Please ask for: Ms Iqraa Malik
Email: iqraa.malik@terraquest.co.uk
Telephone: 0121 234 1390
Our Ref: LU/362/21/HH
Your Ref:
Date: 15th November 2021

Application for Planning Permission for Works or Extension to a Dwelling

Development: Erection of single storey side/rear extension including the installation of 2 x rooflights to pitched roof.

Location: 1 North Ham Road Littlehampton BN17 7AR

TITLE Existing Site Location and Block Plan	DRAWING No PL01	DATE 04/11/21

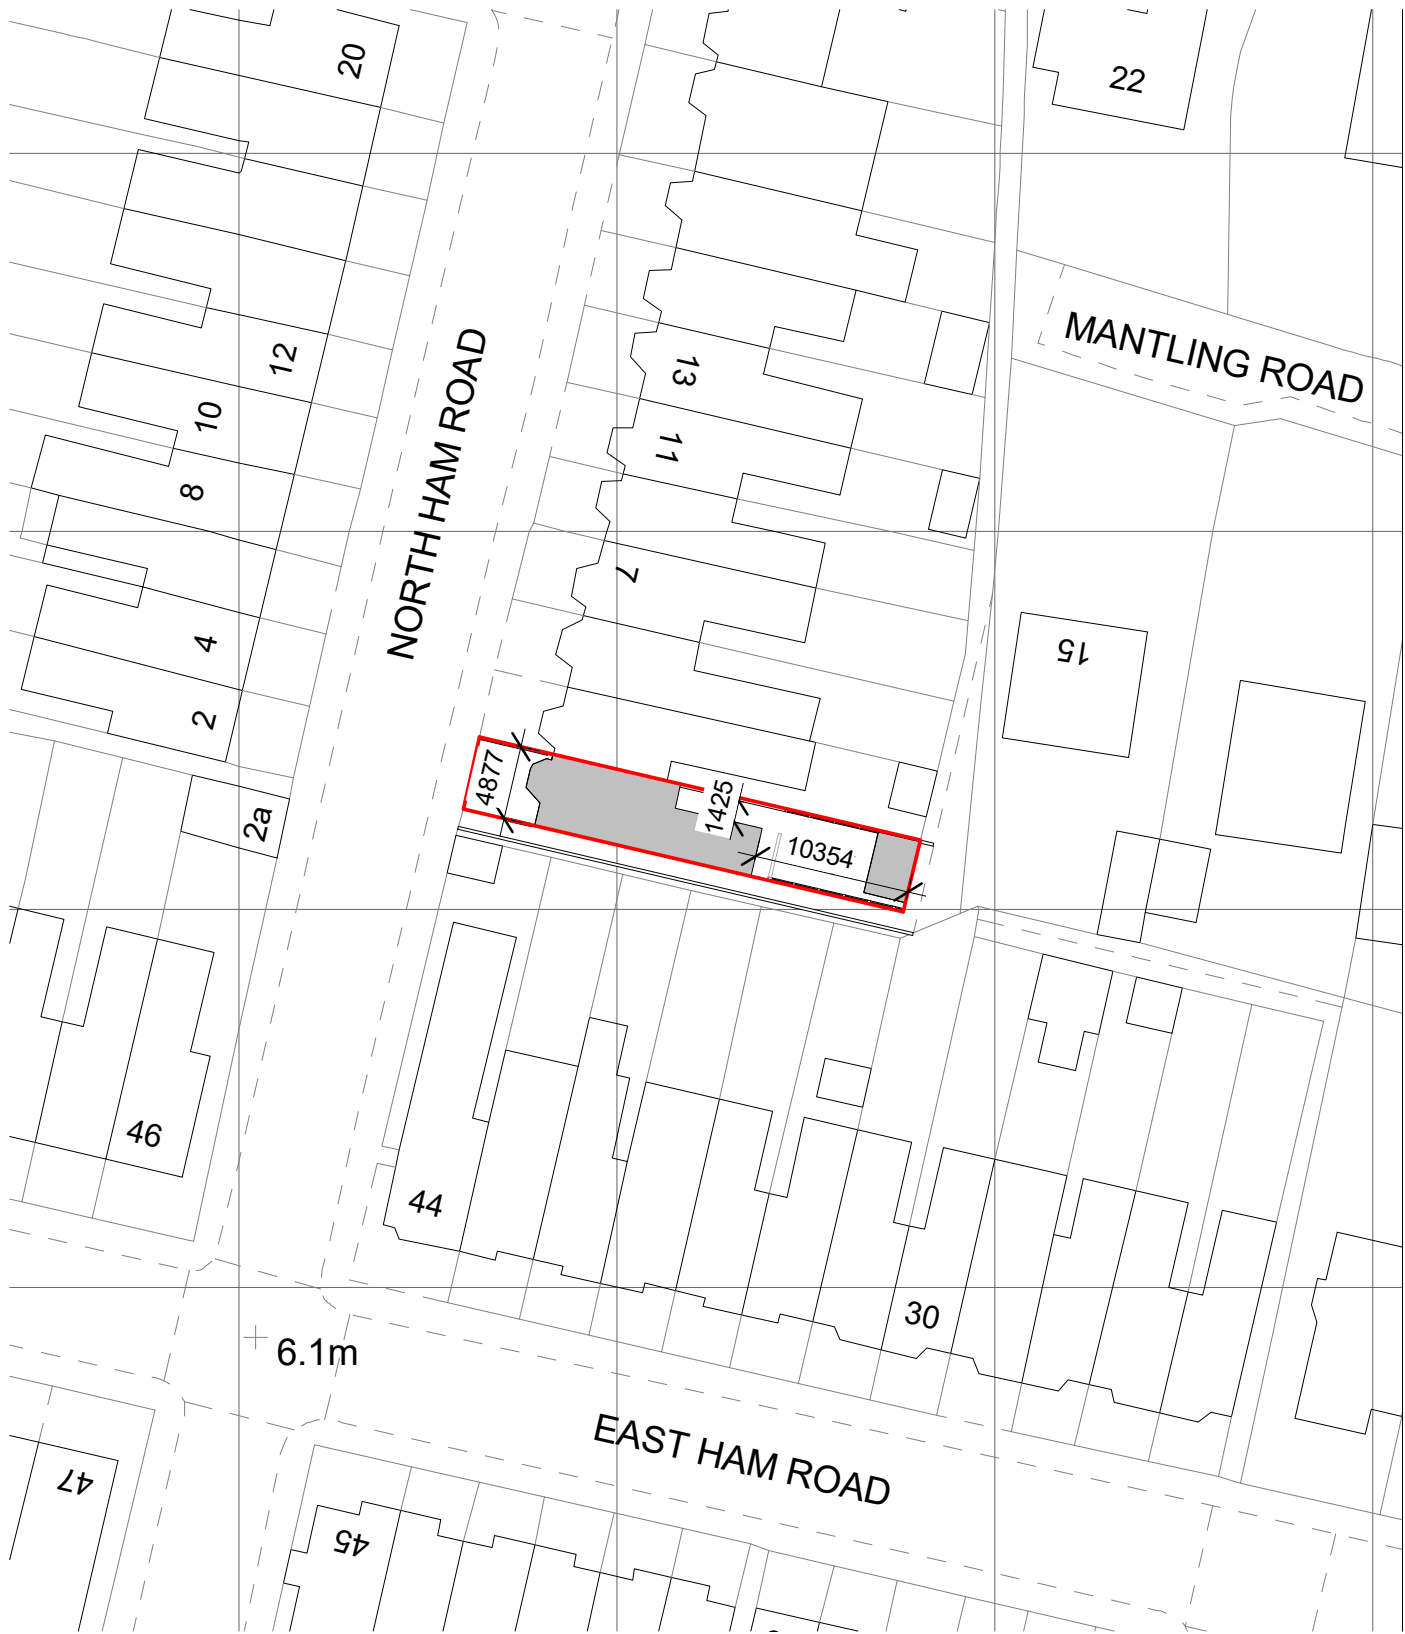
Block Plan

You are required to have dimensions from the proposed extension(s) to all site boundaries. Please amend.
